Kate Brown  
Clerk to Wroxton Parish Council  
10 Priory Vale Road  
BANBURY  
OX16 4FR

Our Ref: **19/01149/LB**

**Application No.:** 19/01149/LB

**Proposal:** Refurbishment and repair of North Arms with Change of Use and conversion of stables into private dining facility and ancillary facilities with new smoking shelter and underground LPG tank

Drawing
Proposed Elevations

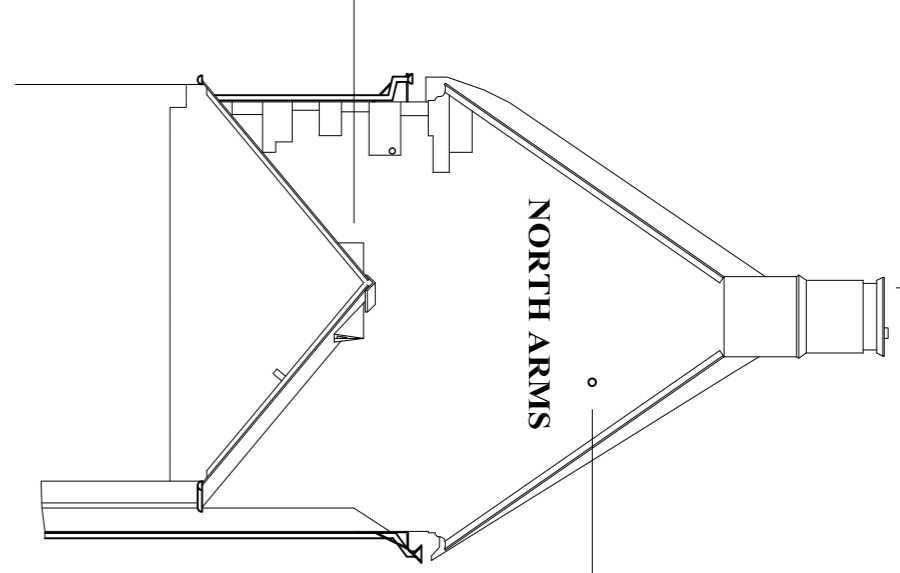
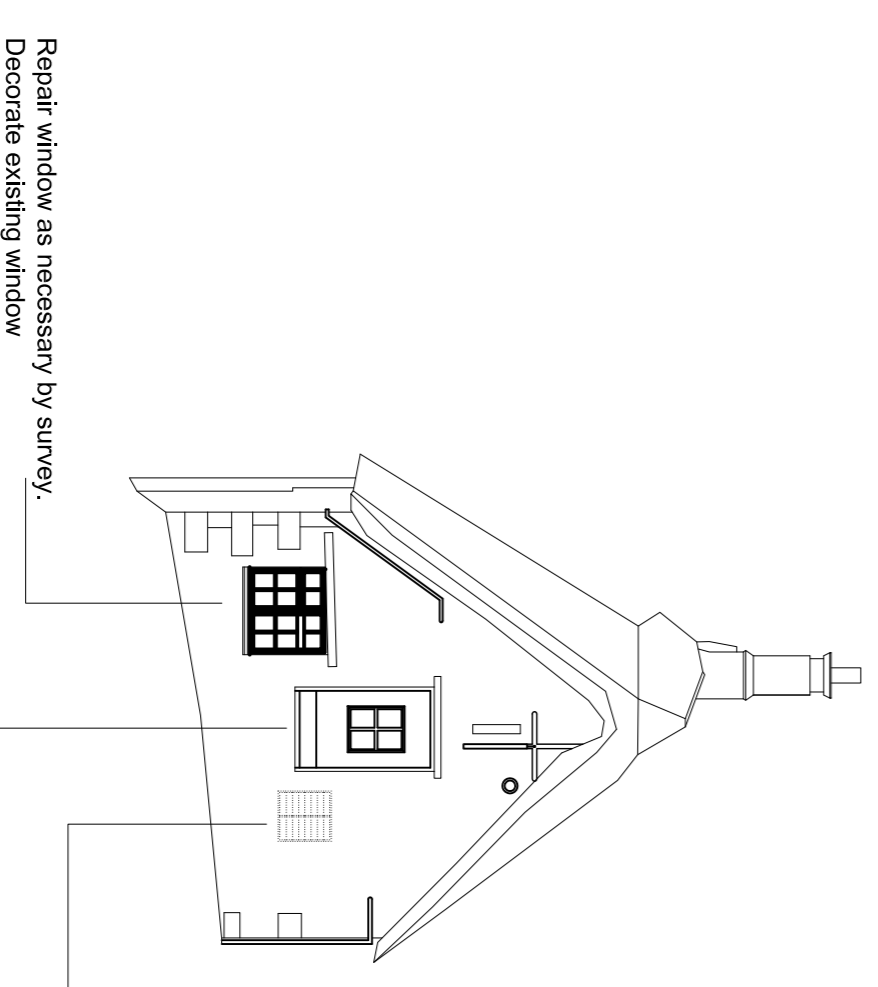
1. Concern at the approach to the Pub down a very narrow Mills Lane and parking in both Mills Lane and Church Street at the rear. The Dean offered to make the College car park available to users of the new facility although the car park is some distant from the Pub. 2. The main concern expressed by adjacent residents was the noise and odours from the kitchen extraction unit.
